**KIRKLEES METROPOLITAN COUNCIL
INVESTMENT & REGENERATION SERVICE**

Reference No: 2018/62/93906/E

Site Address: 4-5, Mazebrook, Drub, Cleckheaton, BD19 4BT

Description: Demolition of barn/workshop and erection of detached dwelling with attached garage

Title Proposed Site Layout							
Client Mr & Mrs T. Skirrow							
MWA Project Ref 6198	Scale 1:200	Original Paper Size @ A1	Paper Orientation Landscape	Drawn MW(J)	Checked		
File Identifier Project	Originator	Volume	Level	Type	Role	Number	Revision
TSDL - MWA - 01 - GF - DR - A - 0005 B

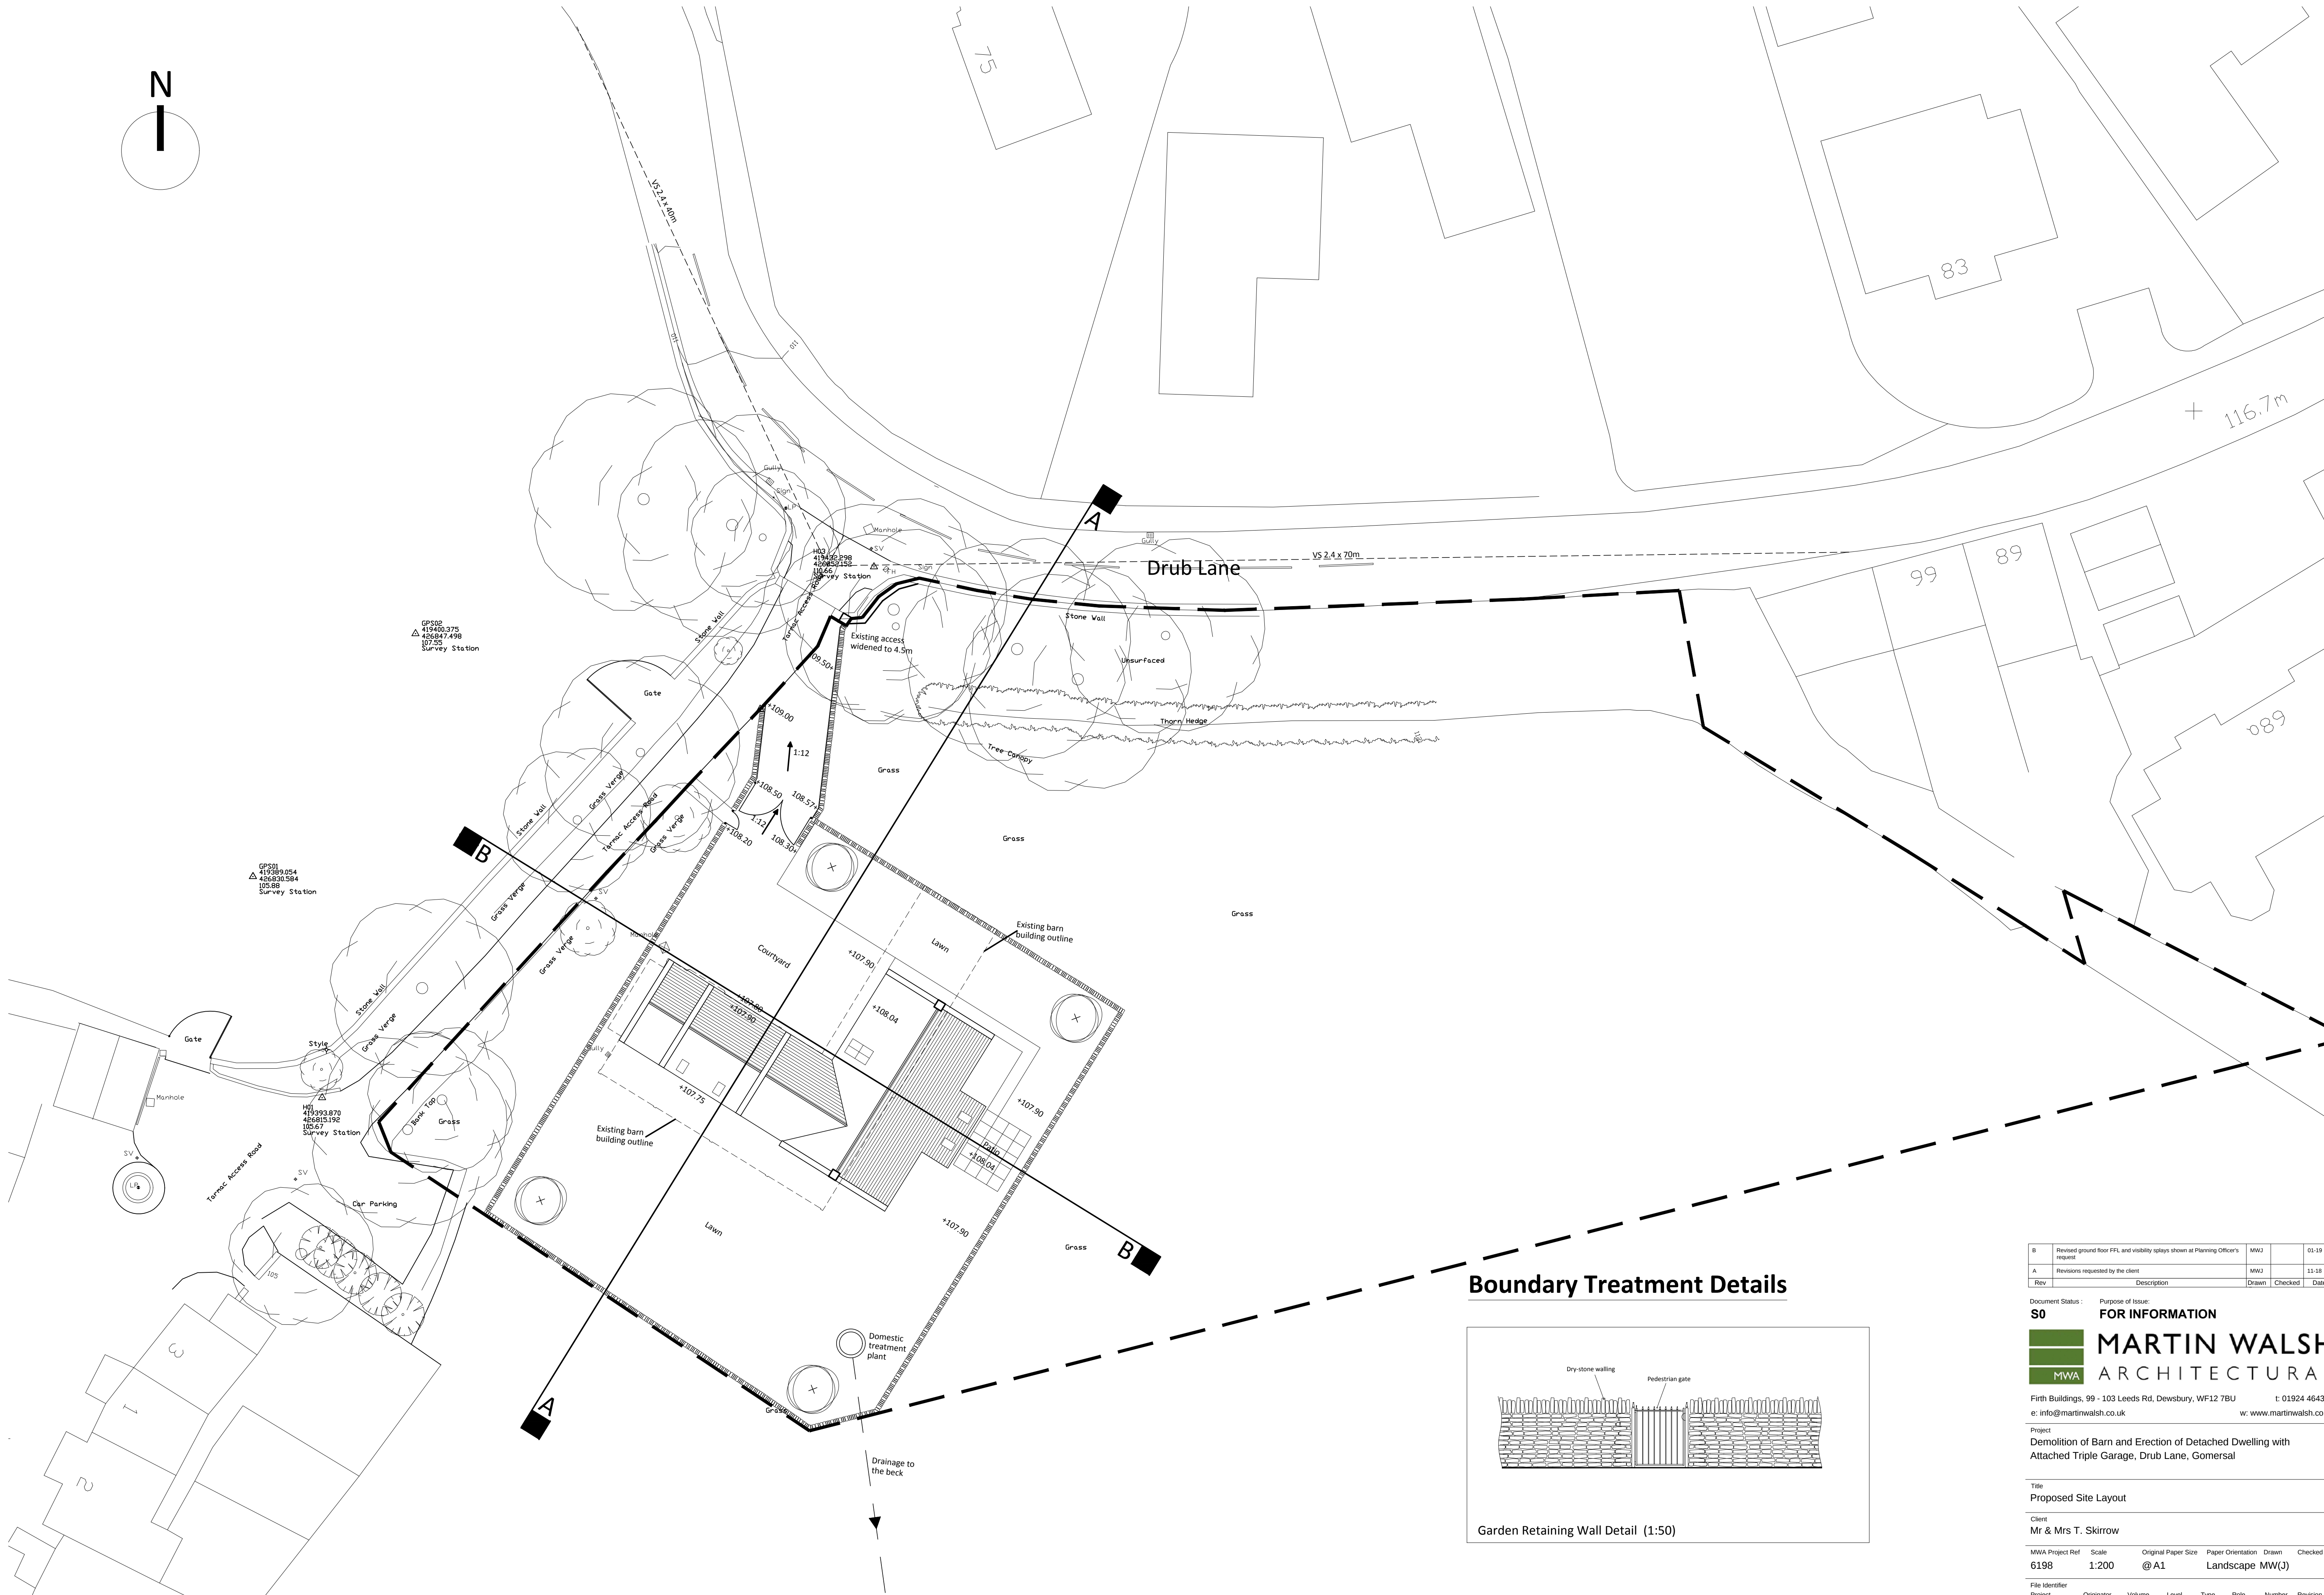
- Amended Elevations indicating amended roof pitch
- Proposed Street Scene
- Additional information relating to proposed sewage treatment plant
- Amended sight lines in accordance with KC Highways DM consultation response

There is sufficient off-street parking within the application site to accommodate parking requirements in line with the Council's parking policy. In addition, there is an existing bin presentation point adjacent to the highway to accommodate bin collections as required. Finally, an additional plan has been submitted through the course of the application demonstrating adequate sight lines at the junction with Drub Lane.
